LDG- 088045-26

Re: Appeal Submission Regarding Proposed Development Adjacent to Rockfield,
Railpark, Maynooth

Planning Reference No: 25/61119

Figure 3.1: Western Boundary Treatment Drawing

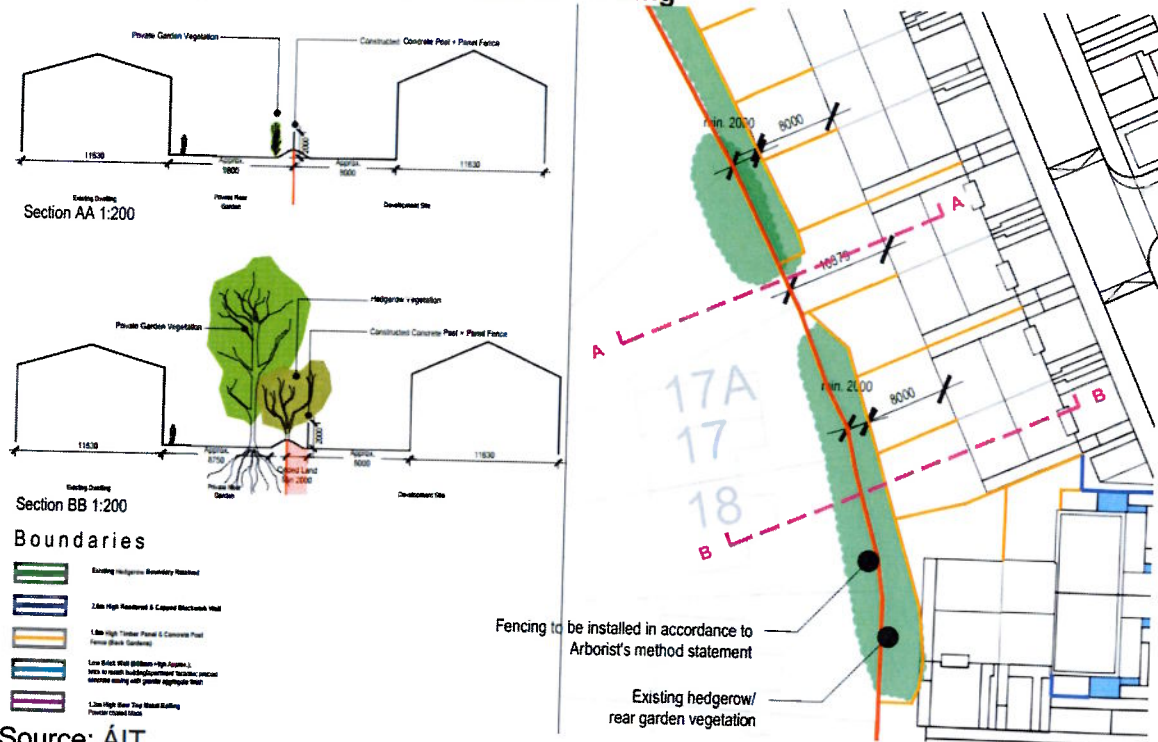
The proposed use of a **weld mesh/Hercules-type fence** in place of a solid wall is unsuitable where existing family homes directly adjoin the new development.

A transparent fence:

- Fails to protect privacy, particularly for children
- Allows visual intrusion into rear gardens
- Does not prevent vegetation encroachment
- Provides insufficient security
- Facilitates litter accumulation and anti-social access

A solid boundary wall of appropriate height and finish is required to:

Figure 3.7: Extract of Layout illustrating 'cul de sac'

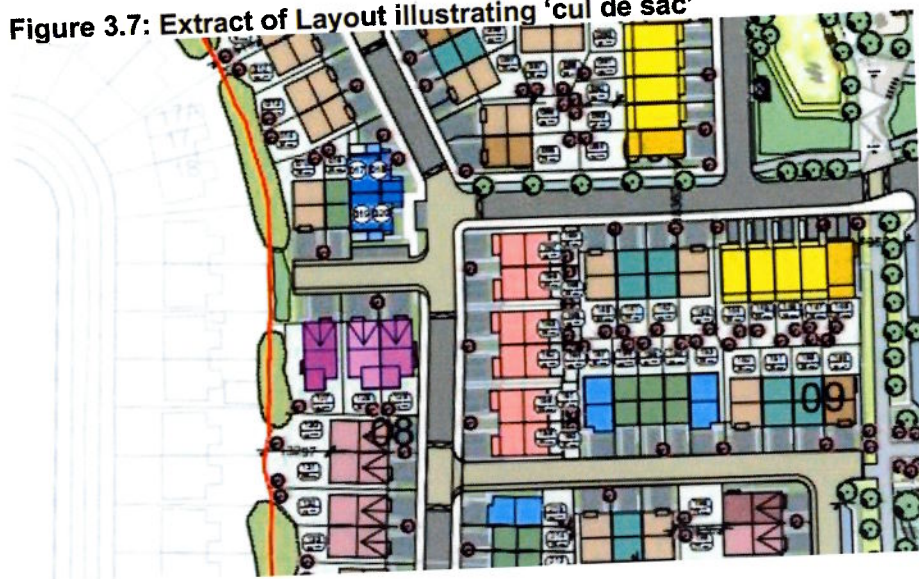
The proposed cul-de-sac directly behind existing homes raises serious concerns.

A roadway and turning area in this location creates opportunities for:

- Overlooking
- Loitering
- Noise disturbance
- Unauthorised access to rear gardens

This arrangement conflicts with good residential design principles and fails to protect the established amenity of current residents.
